Application number: 2021/90800	
What is the application for?:	Redevelopment and change of use of former mill site to form 19 residential units
Address of the site or building:	Hinchliffe Mill, Water Street, Holmbridge, Holmfirth, HD9 2NX
Postcode:

Type of comment: An objection	
Do you wish your comments to be published on the website anonymously?	Yes
<p>1) Over intensification of the site (too many houses) Although the number of houses has been reduced from 24 to 19, 19 dwellings is the indicative maximum capacity allocated for the development site HS190 in the Kirklees Local Plan 2019. (The Local Plan does not identify the size of dwellings so if 19 one-bedroom properties were developed the volume of cars would be considerably less than the 19 three/four-bedroom properties being proposed). If the developer wants to create large size properties, the number should be reduced from 19. The volume of traffic generated from proposed plans will be too high for the surrounding road network leading to an unacceptable impact on highway safety.</p> <p>2) Highway safety. Unacceptable impact on highway safety and severe impact to surrounding road network. Significant danger to the local commu

HOUSE TYPE : UNIT 1

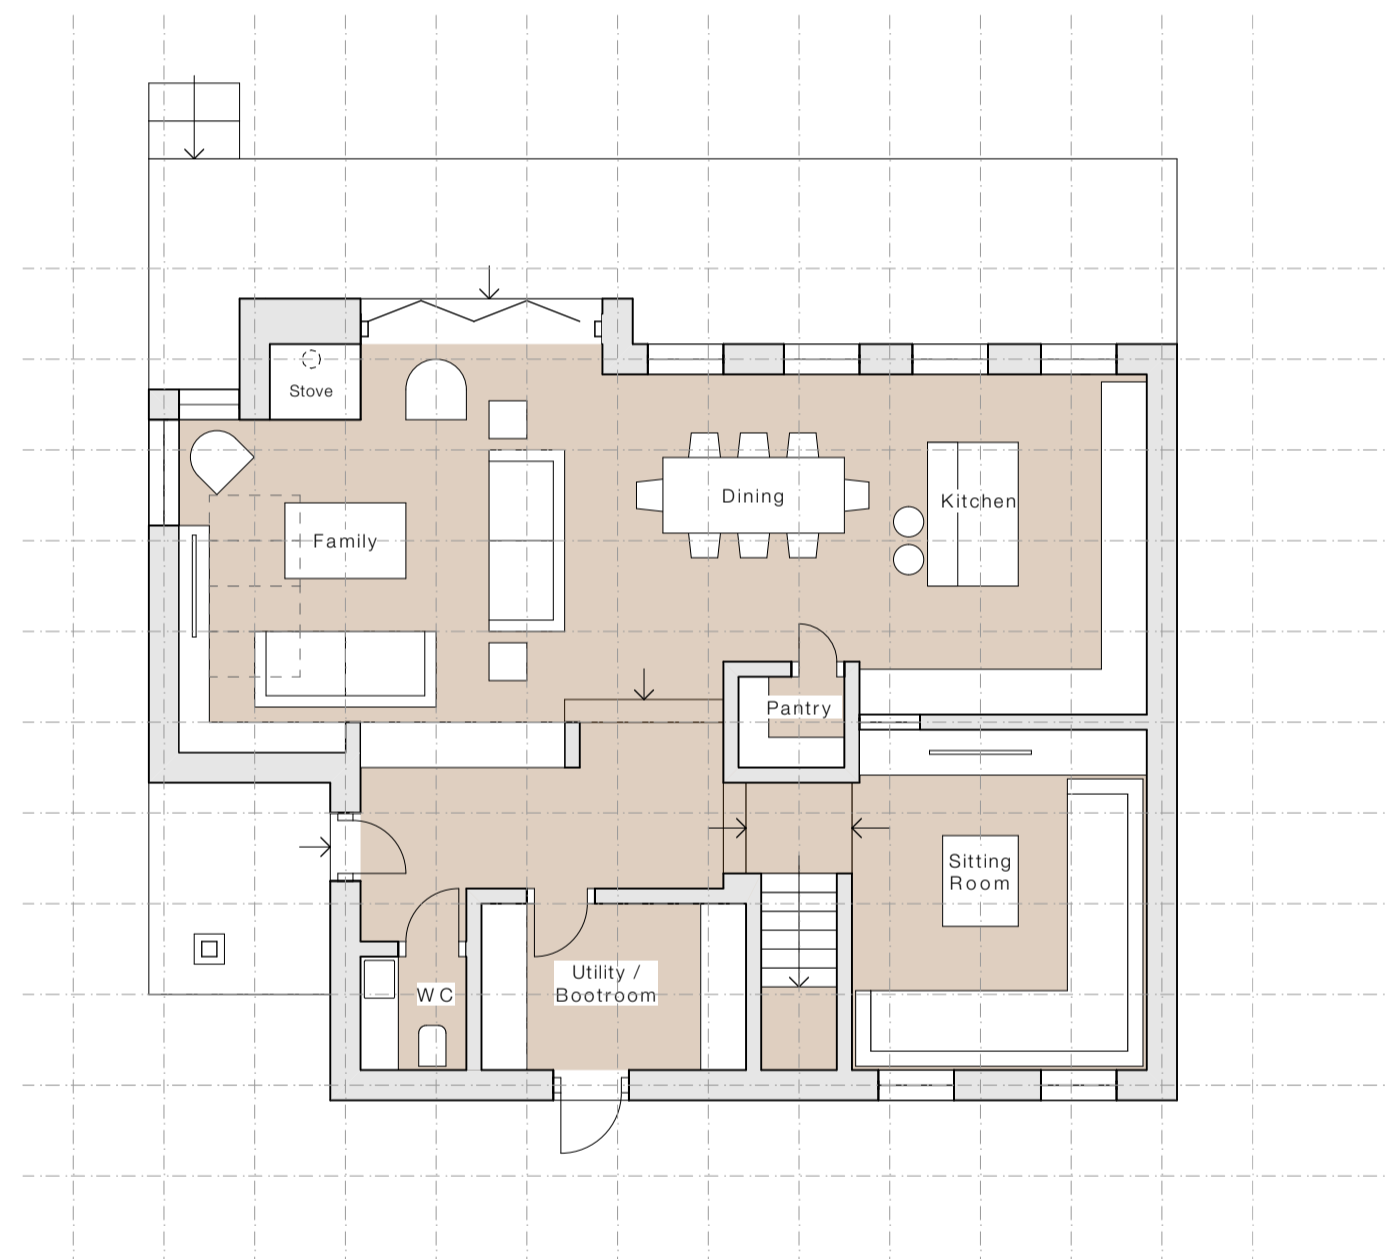
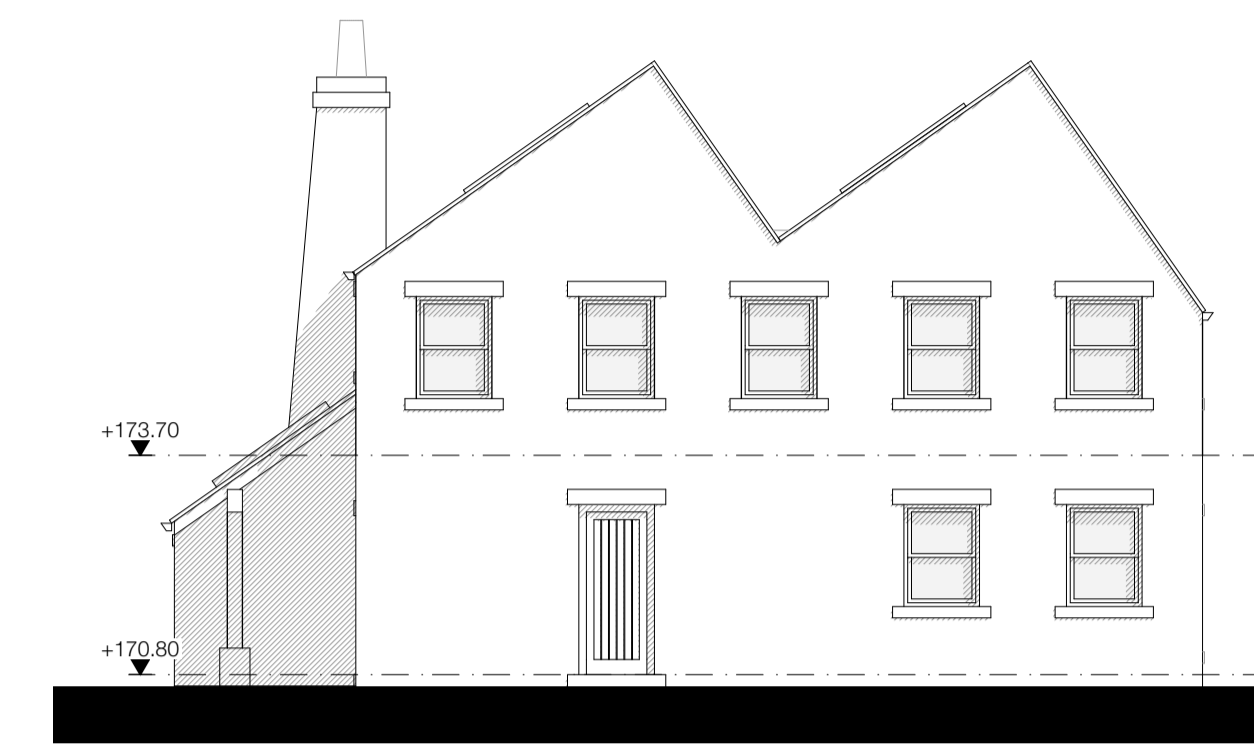
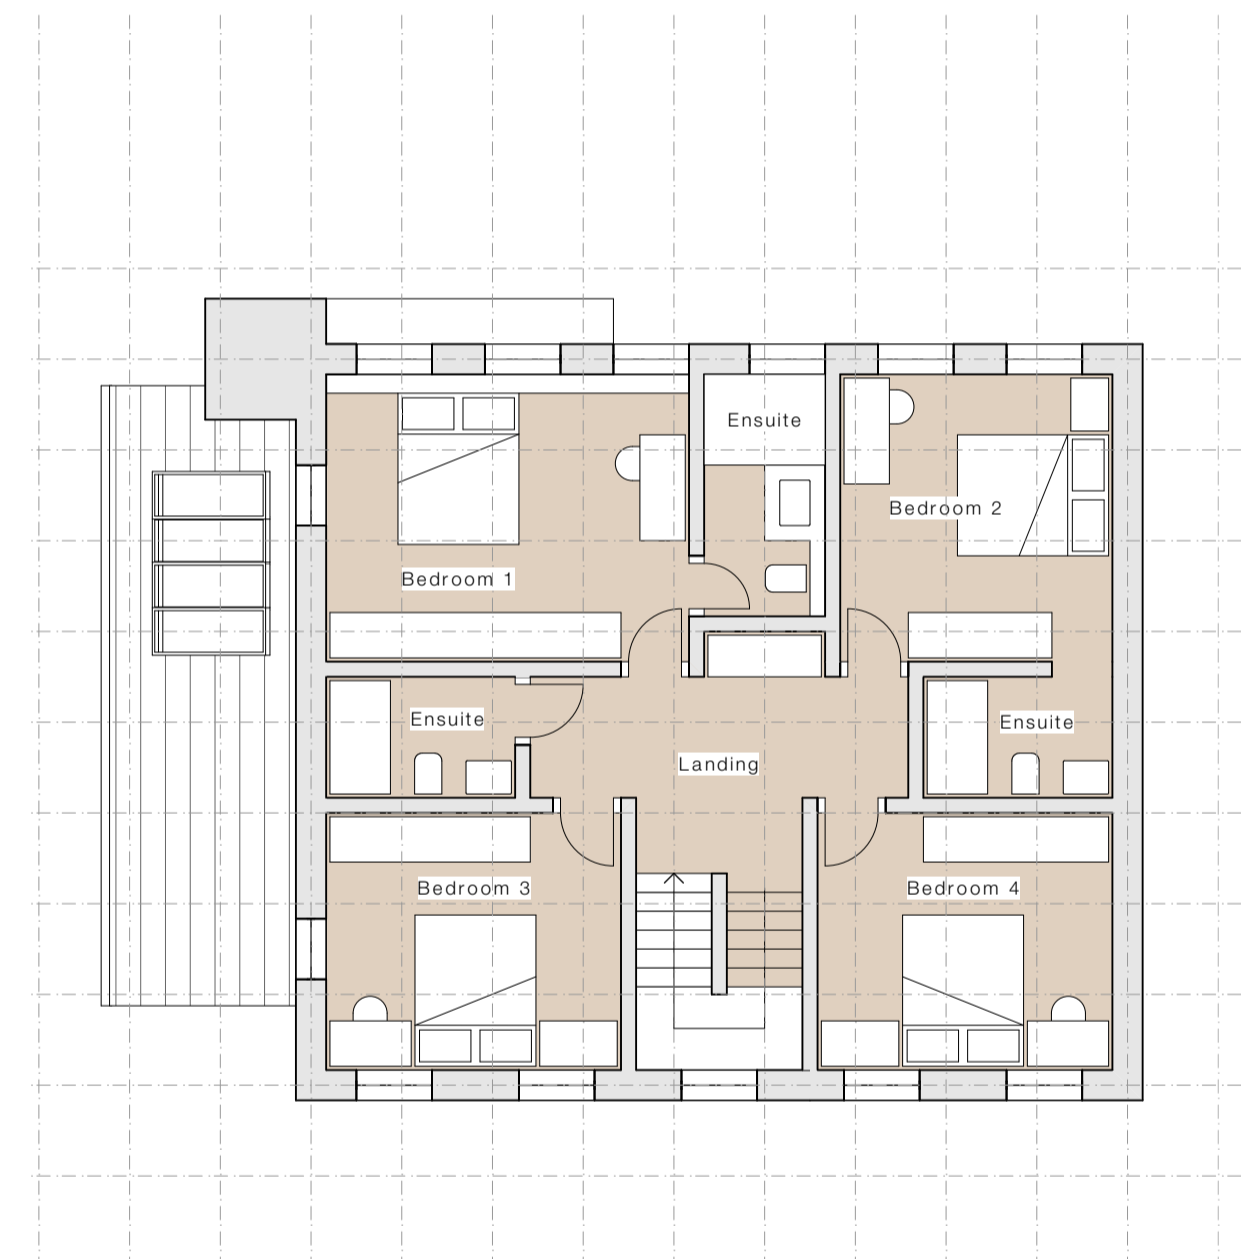
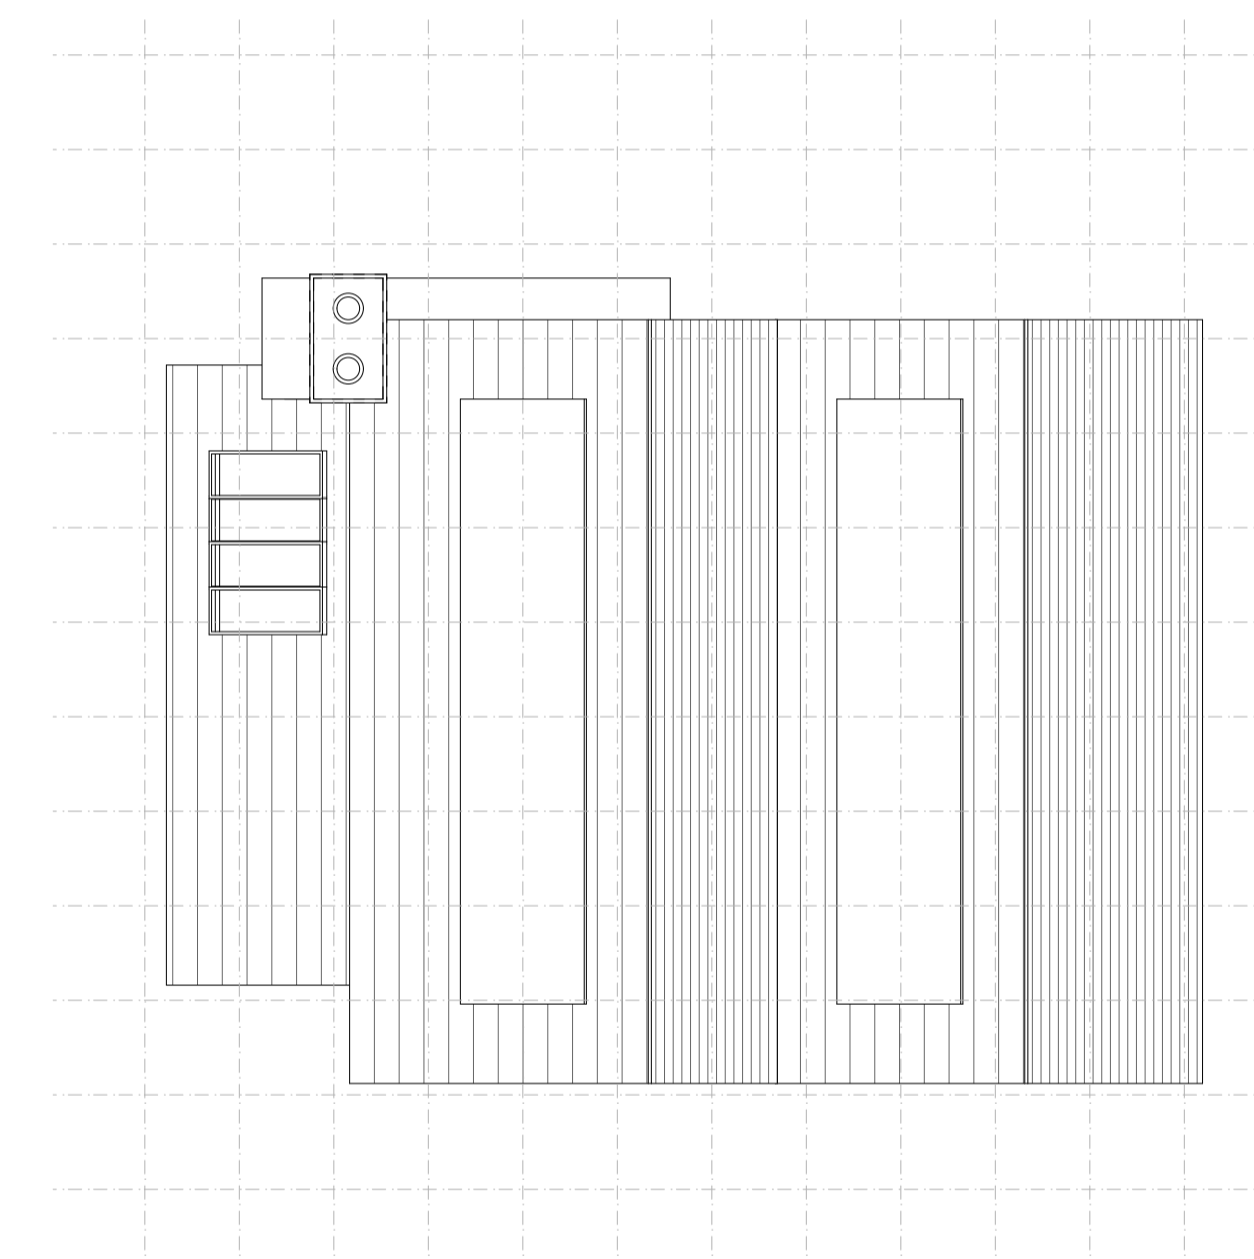
4) Scale and Massing (size). The scale and massing of plot 1 & 2 directly adjacent to the mill building, overlooking the dam are unduly dominant and out of scale with the heritage Class 3 asset mill building which would lose its local prominence, adversely affecting its village-scape merit and immediate setting. Historic England submitted concerns that previous plans presented a 'domestic' feel, at odds with the industrial character of the site which would not preserve or enhance the special interest of surrounding designated and non-designated assets and would be harmful to the character and appearance of the conservation area, and consequently cannot be supported. Complete removal of plot 1, or further reduction in scale and massing of plot 1 & 2 is required. Further design consideration is needed in keeping with the context of the industrial setting and surrounding properties in this conservation area.
